CITY OF ALBUQUERQUE

March 5, 2019

**Re: The New Los Altos Pool,
10100 Lomas Blvd NE, 87123
30-Day Temporary Certificate of Occupancy- Traffic Certification Only
Transportation Development Final Inspection
Engineer's/Architect's Stamp dated 5-17-17 (K20D037)
Certification dated 3-1-19**

PROJECT	5280.00
NO:	
DRAWN BY:	Author
CHECKED BY:	Checker
GREER STAFFORD/SJCI	
ARCHITECTURE	
SHEET TITLE	
SITE PLAN

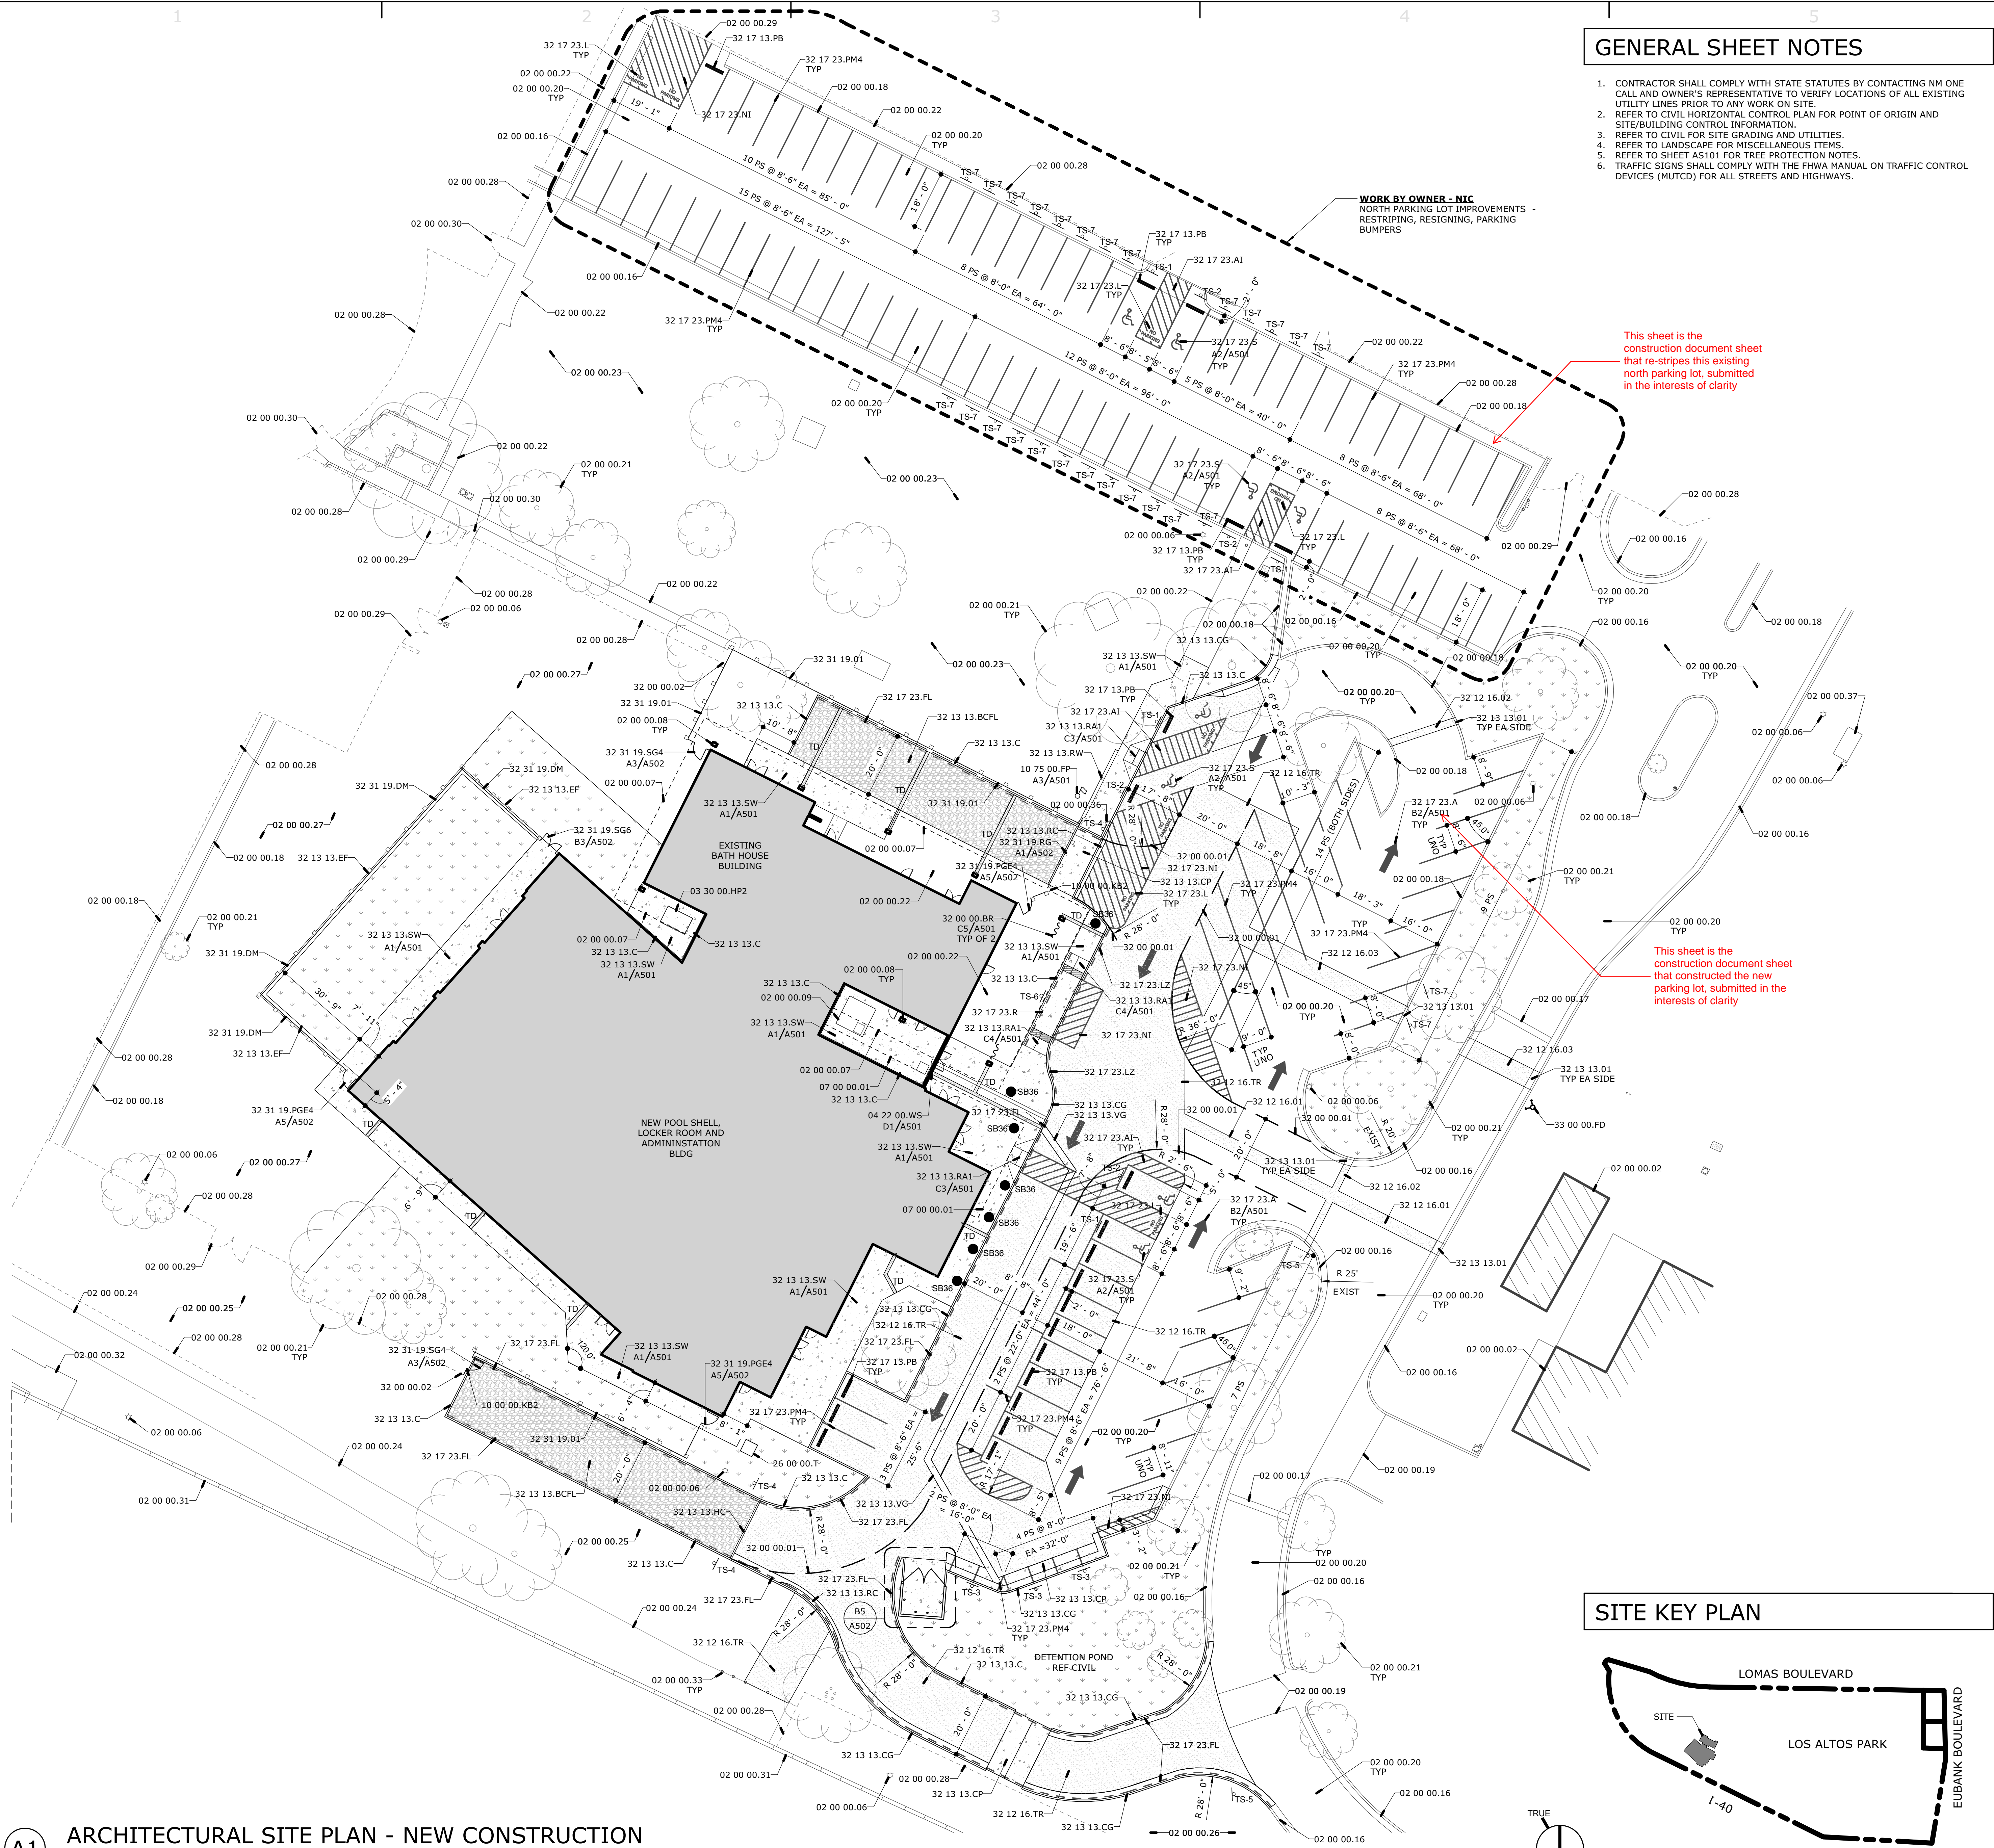
1. Please add bicycle rack.
2. Please add wheel stops to row of parking stalls fronting the sidewalk in north parking lot. (Please see attached photos).
3. Please stripe hatch markings and add No Parking to the unusable space in the north parking lot on the SE corner. (Please see attached photos).
4. Please send photos of corrections to epgomez@cabq.gov for release of final CO.
